December 23, 2019

Kiowa Engineering
c/o Chris Castelli

RE: North Bay – Construction Plan Set

North Bay at Lake Woodmoor
Shoreditch Heights -- 6" Watermain Plan and Profile
12" Water Storage Pipeline Plan and Profile
El Paso County, Colorado

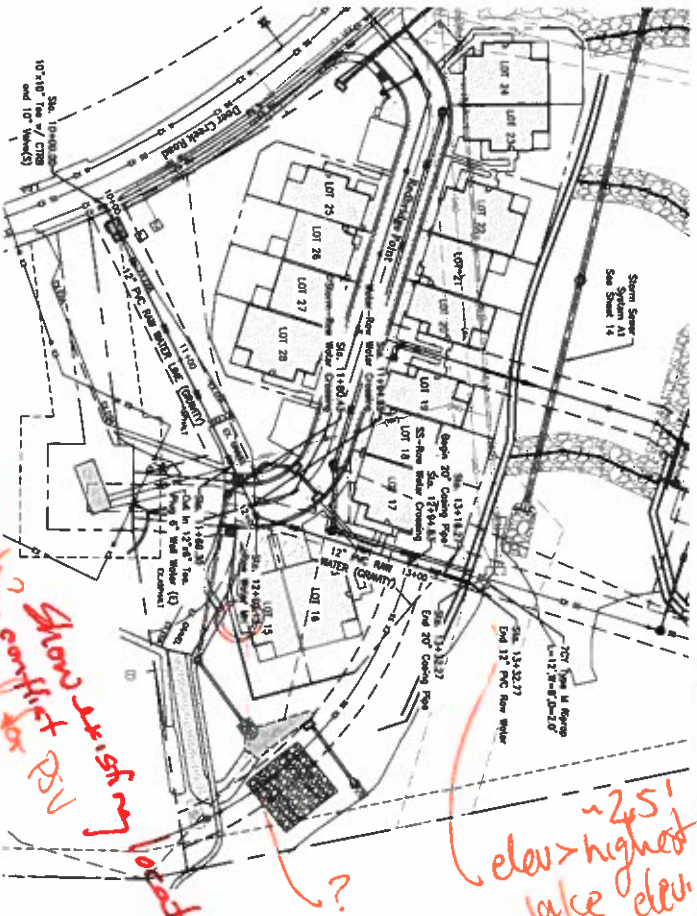
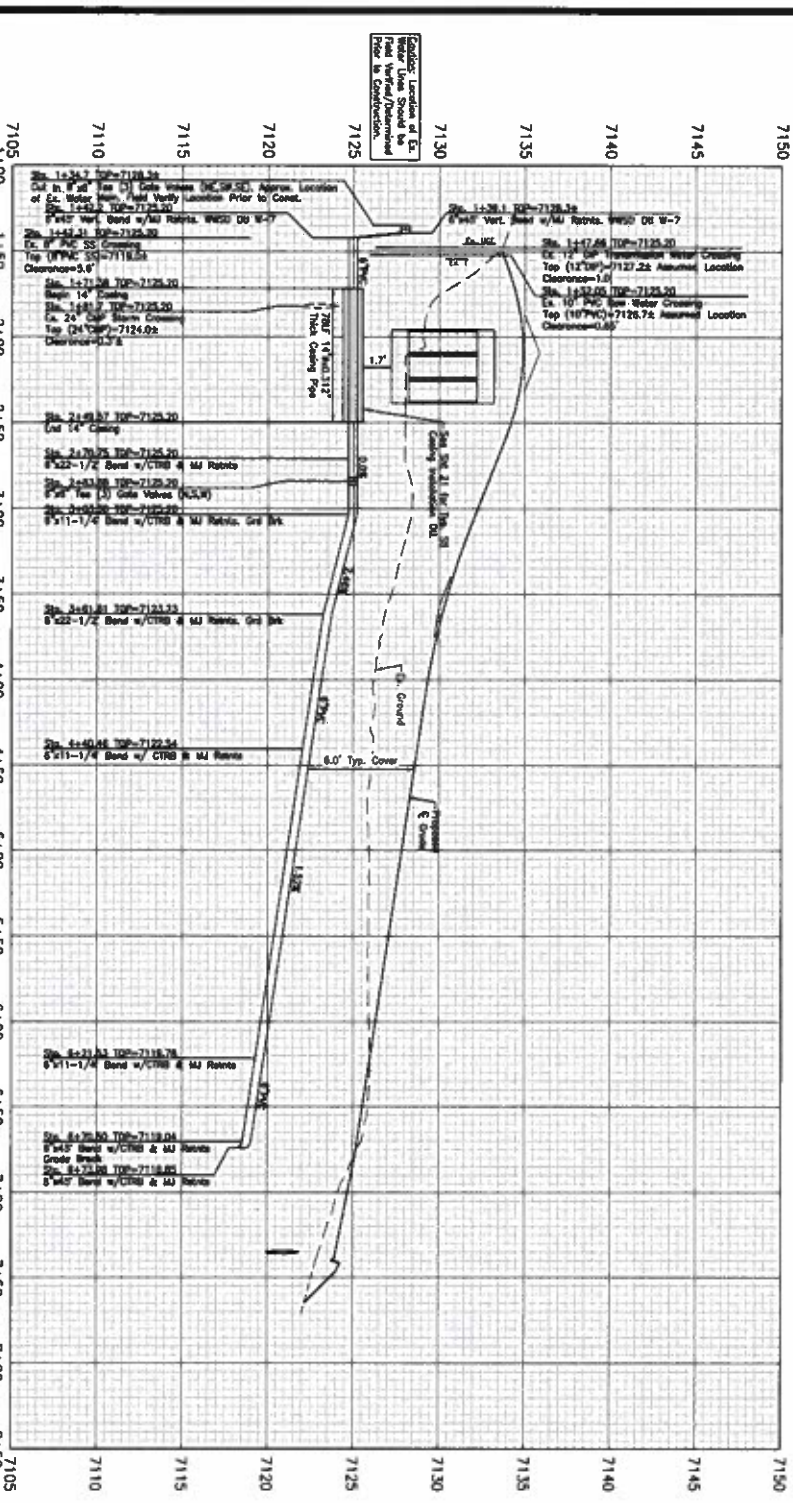
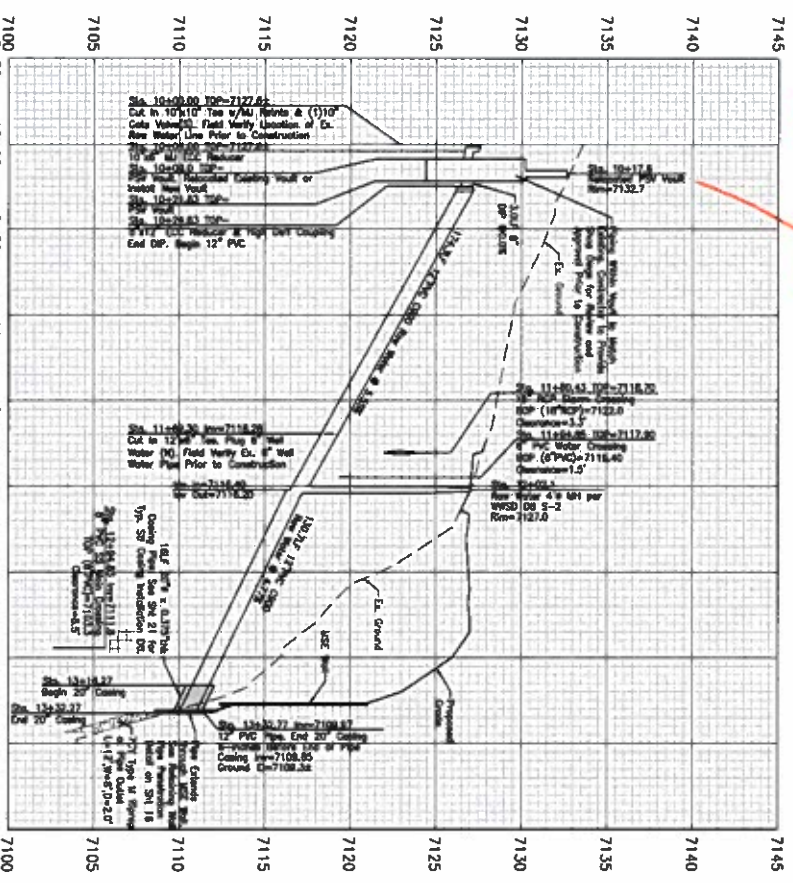
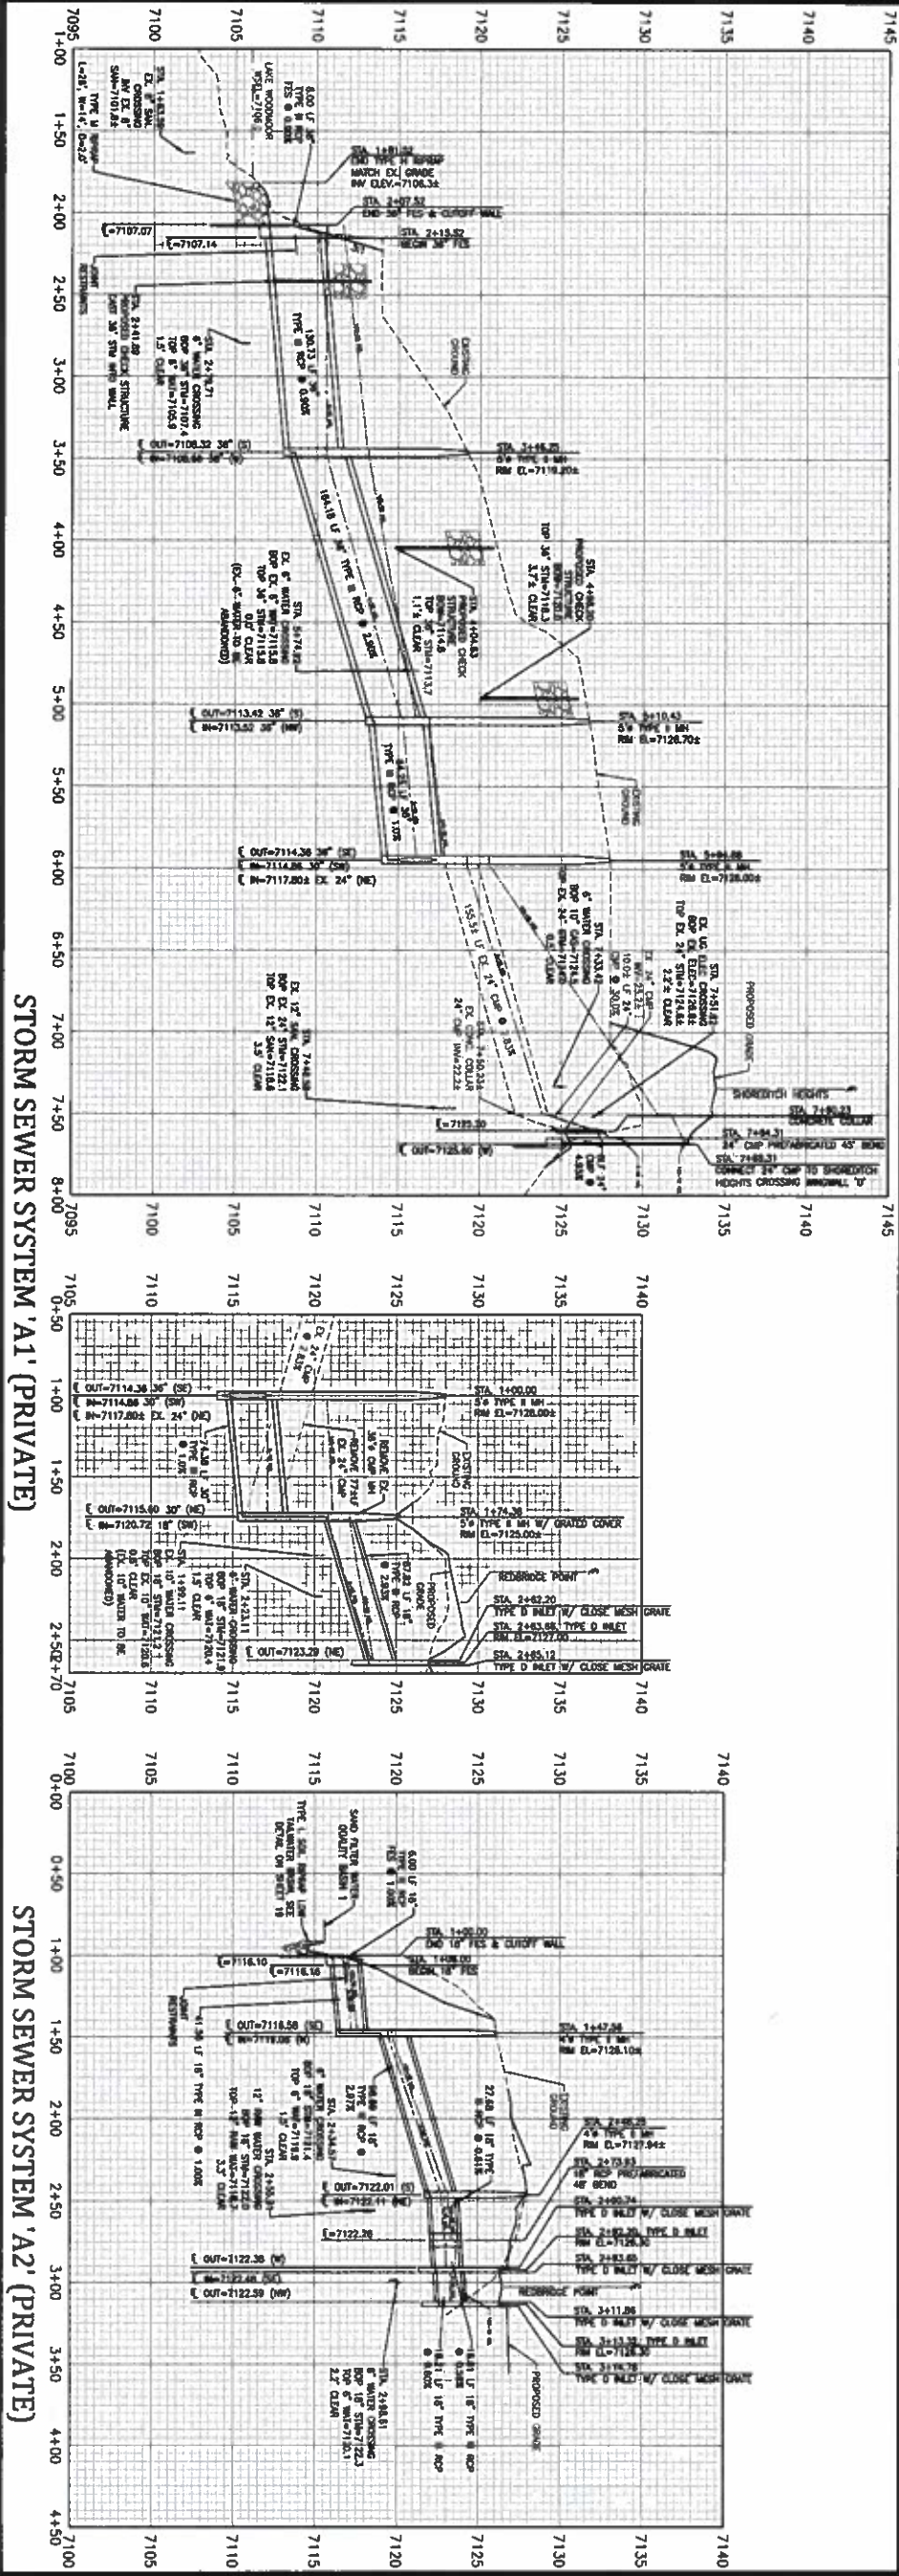
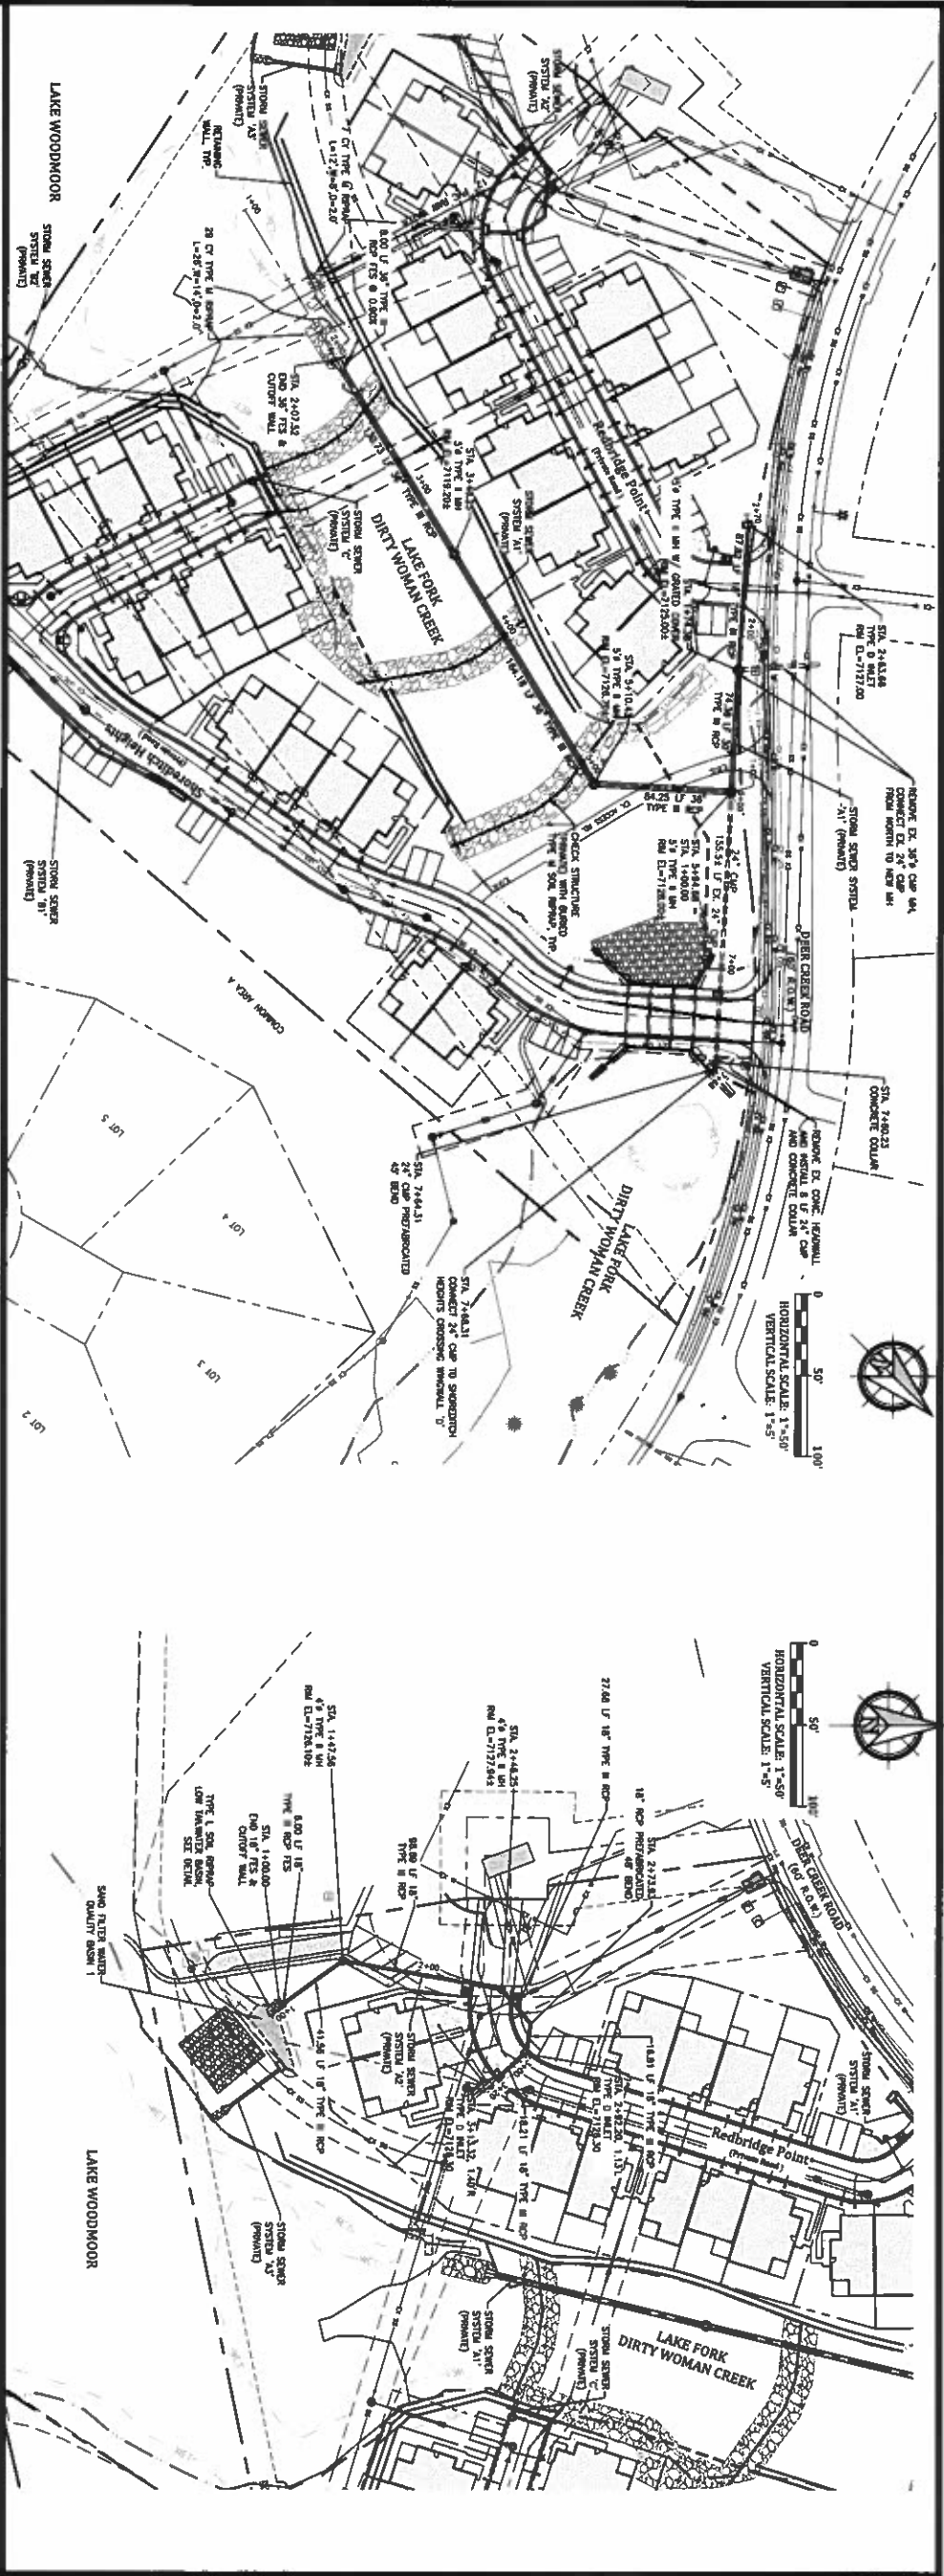
1. Please label and note the width of all easements.
2. On the Shoreditch Heights profile, the water pipe deeper than 15 feet should be Ductile Iron Pipe.
